Our Case Number: ABP-312606-22

Your Reference: Ballinagree Wind DAC

Re: Wind farm development of 20 turbines with 110kV electrical substation and all related site works and ancillary development.

Please be advised that the Board, in accordance with section 37(F)(1) of the Planning and Development Act, 2000, as amended, hereby requires you to furnish the following further information in relation to the effects on the environment of the proposed development: .

- Notes.**
- This drawing is for planning purposes only.
 - Dimensions in meters unless otherwise noted.
 - Levels shown relative to ordnance datum (Mal)
 - Co-ordinates are to Irish Transverse Mercator
 - Extent of earthworks not shown.

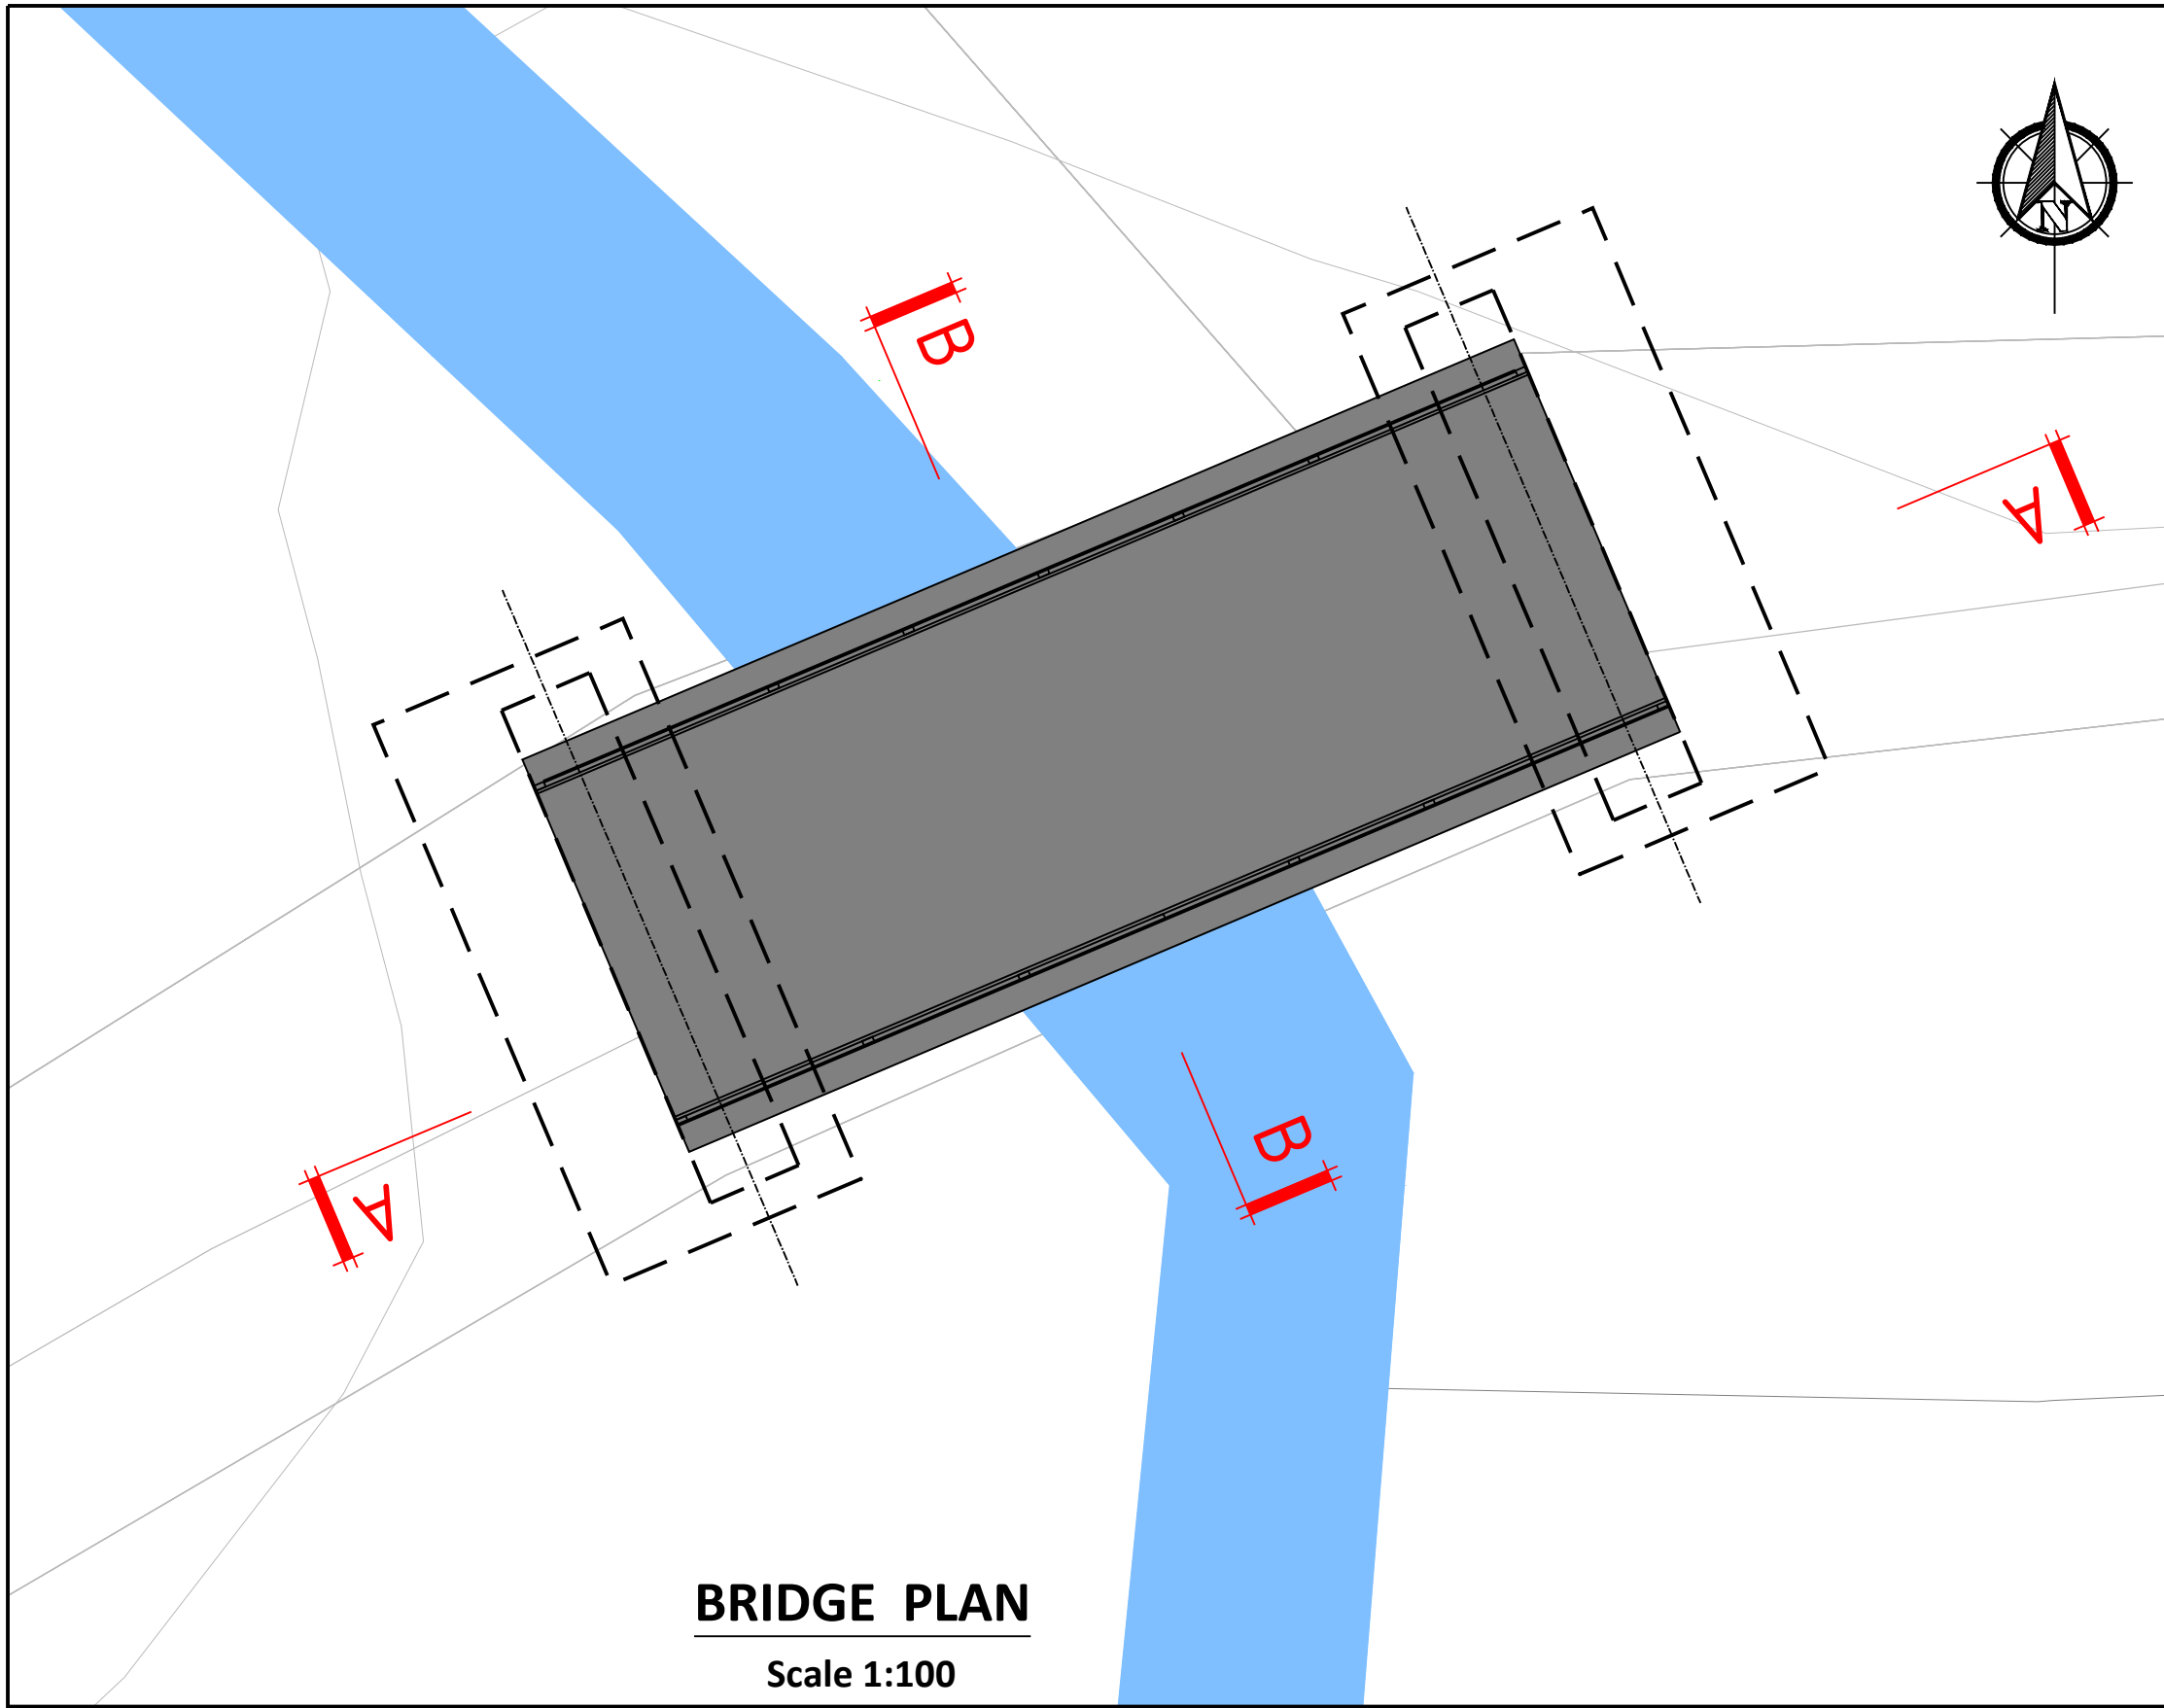
- (d) Confirm whether the design of watercourse crossings WF-HF5 and WF-HF8 complies with OPW requirements.
